From: Louise Bearcroft
Sent: 24 March 2026 15:15
To: DC Admin
Subject: FW: Objection Planning Application 2025/92713 Re: TPO Number 05 of 2025

Please can you log this as an objection to 2025/92737 and 2025/92713.

The most recent plan uploaded by Kirklees Planning [id1130493] dated 12.03.2026 is still showing tree T16 as its actual size but showing G17 group of trees, smaller, just marginally larger than the garage shown to the right of them. Therefore the root balls are shown as extending only just over the boundary whereas the branches of these trees extend further over the boundary than T16's do. As stated in my original email some of the branches from these cherry trees extend to approx. 5 metres over this proposed development site.

Client PPJ Developments  
 Project 2539 : Moor Lane : Residential  
 Title Proposed Site and Section

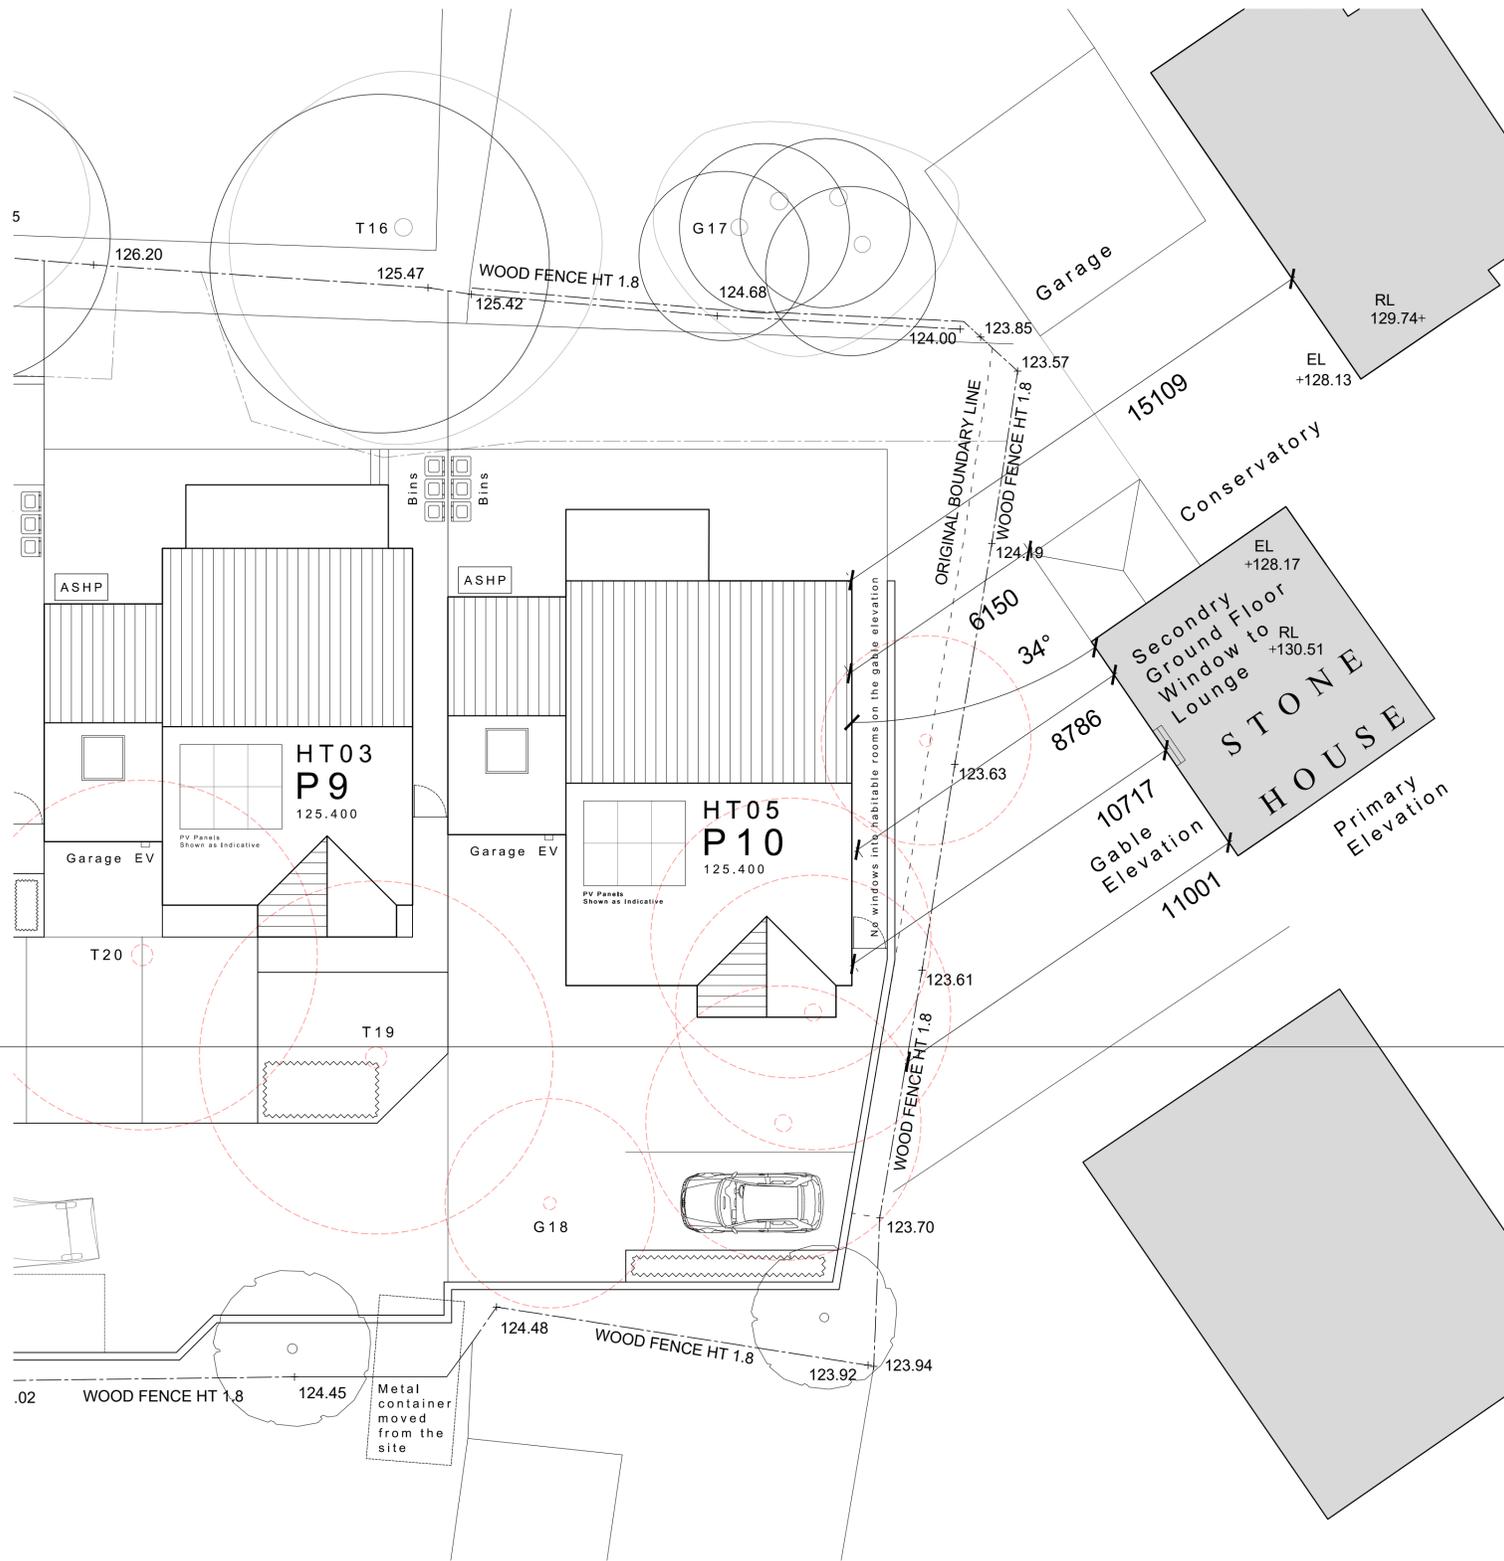
This TPO does not seem to have been acknowledged because the true **status, size and quantity** of our cherry trees have not been updated on these amended plans. This means the size of the trees and the root balls are being shown to be considerably smaller than the tree growing to the left, **(West)** on the plan labelled Proposed Site / Block Layout [id 1124987 **T16 (Protected TPO Tree)**]. Some of our mature cherry trees are as big as T16. Therefore the trees in my garden have been given far too little root protection area that should have been allocated, to protect these beautiful trees, from this developer.

- 3) Please can the developer and his agent be advised to update his planning application plans, to show that the trees, with-in our boundary (curtilage) are shown to be **the correct size, the correct quantity and in the correct positions?**

- 4) Please can the developer and his agent be advised to show the tree canopies on his plans that are the correct size, proportion and diameter as TPO Tree T16, as people may be **mislead** into thinking that these trees are smaller than they really are.

Appendix 5: Tree protection plans

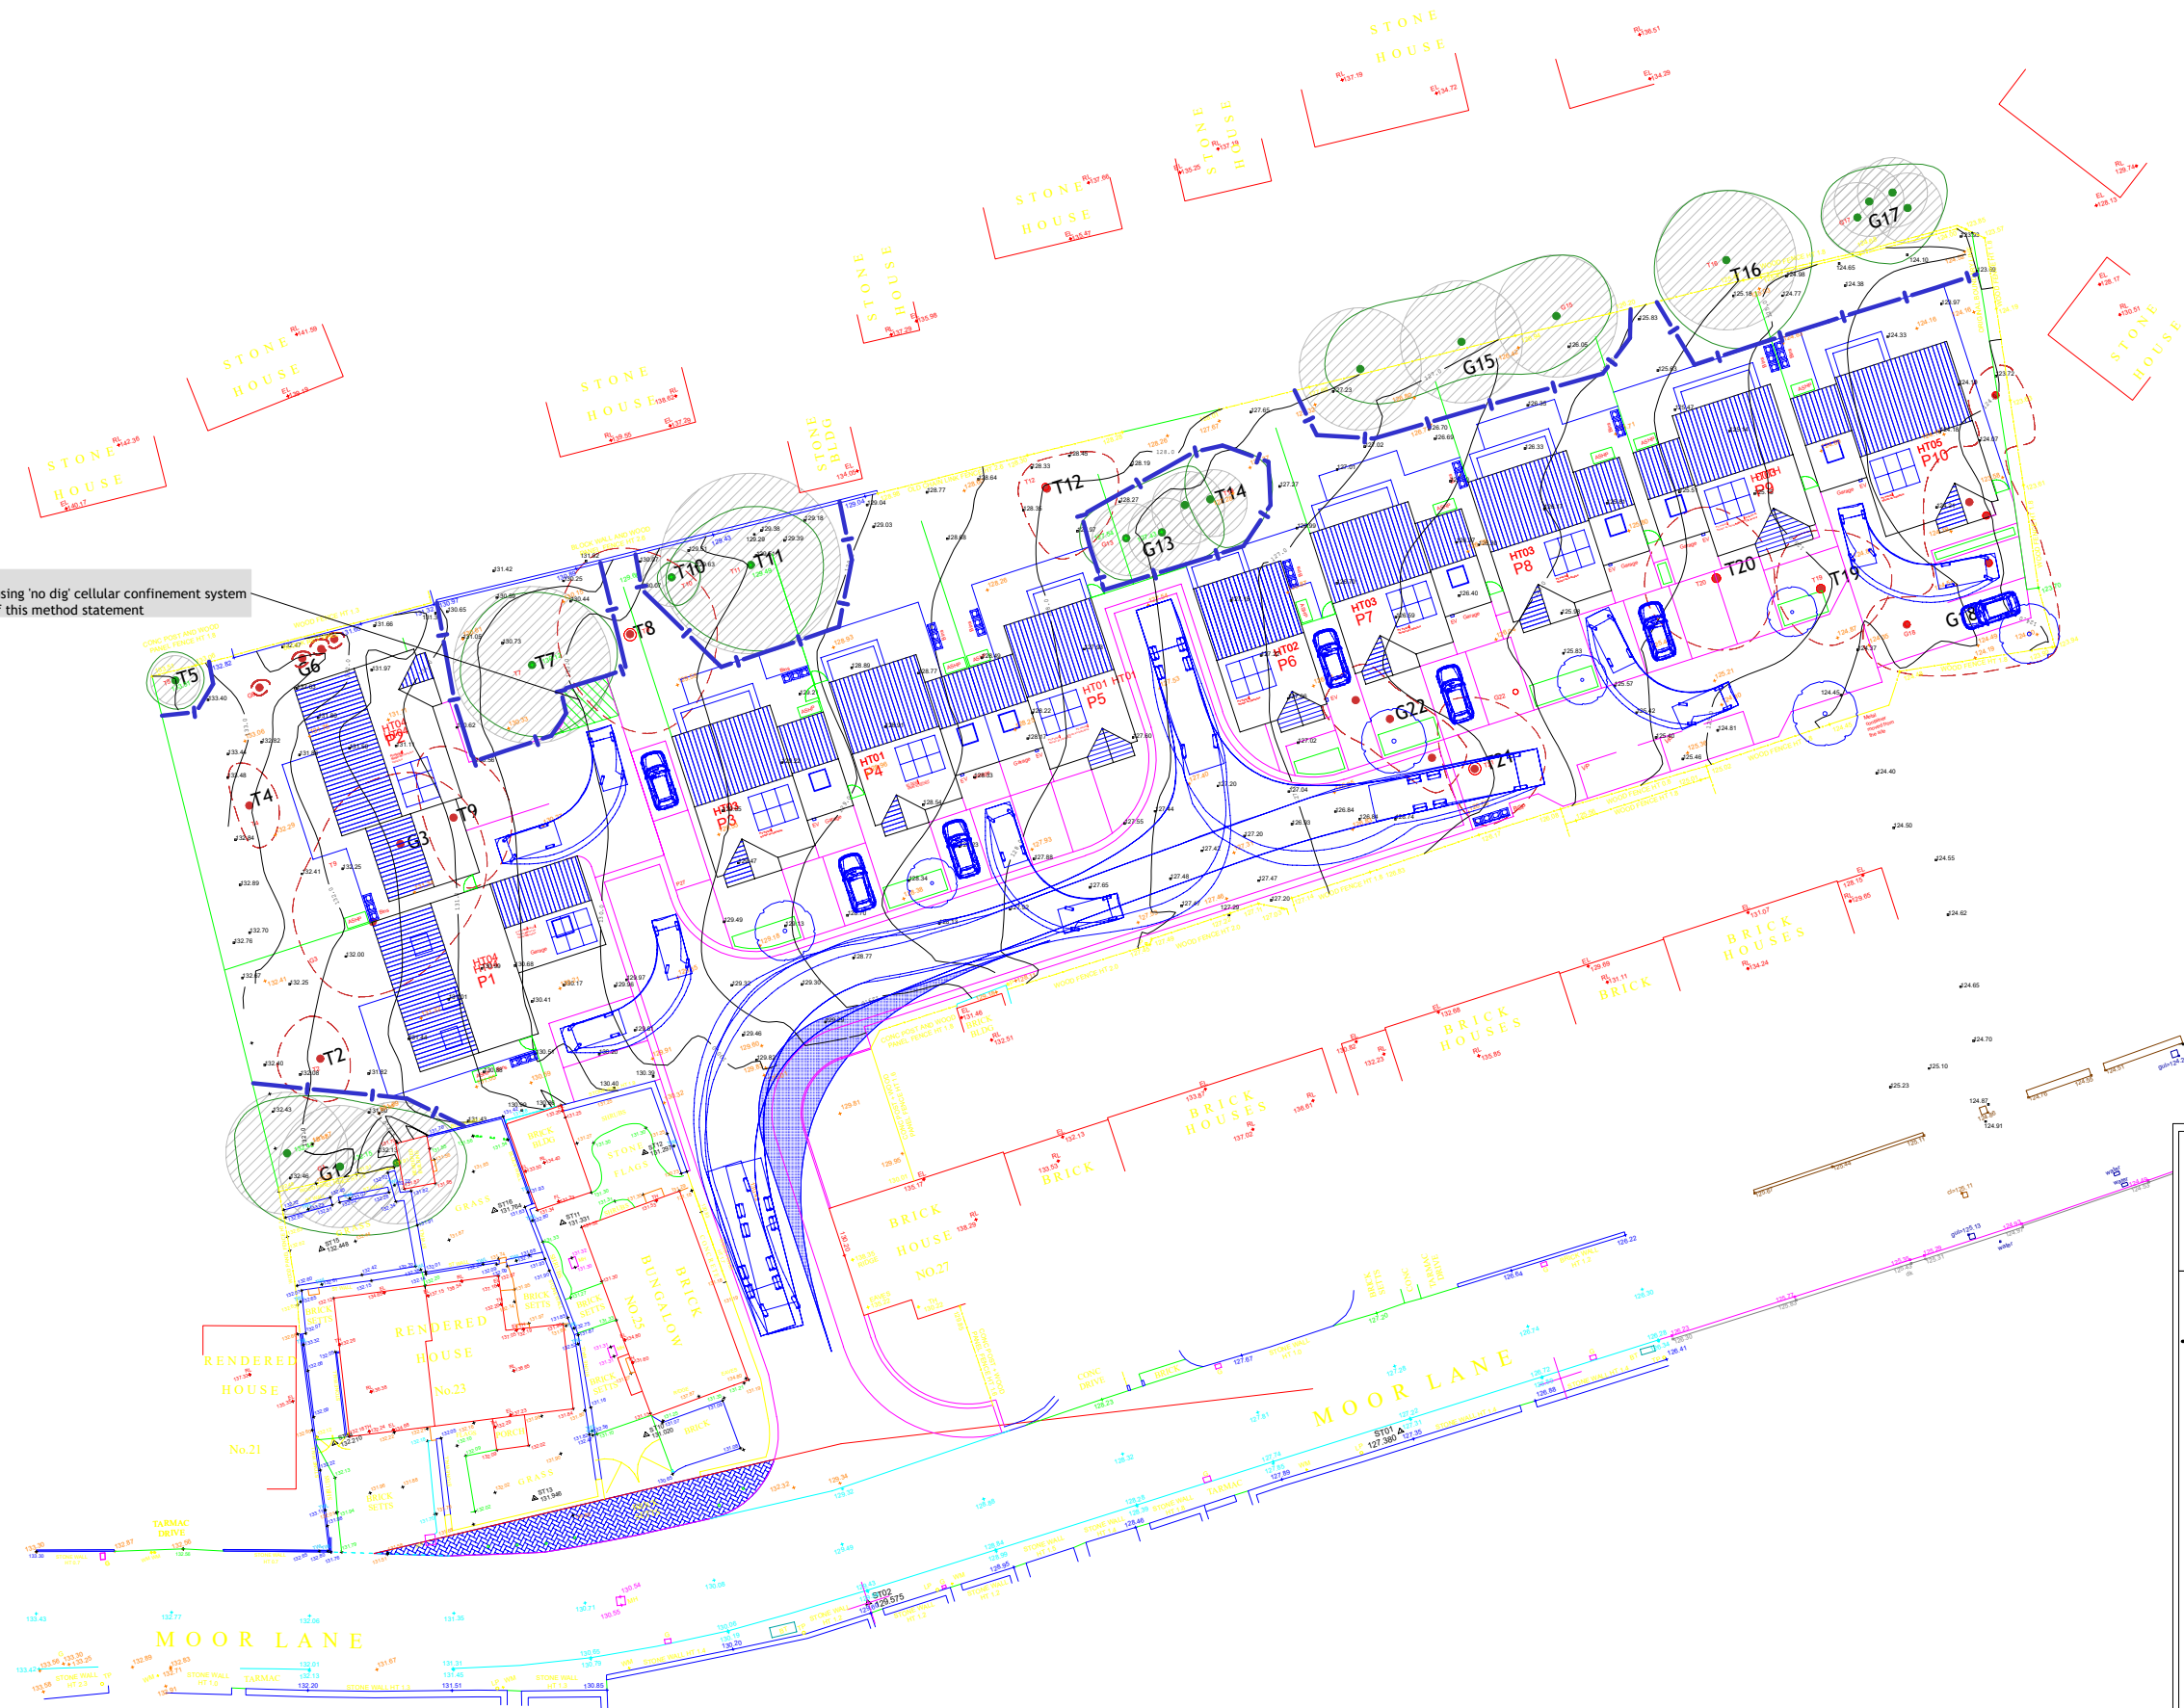
Despite numerous emails to planning officers, TPO officer and legal officer the plans for planning application 2025/92713 and 2025/92737 have not been updated to show the correct sizes, location

and classification of these trees having a TPO on them. Consequently the root protection area on these plans are not of the correct dimensions.
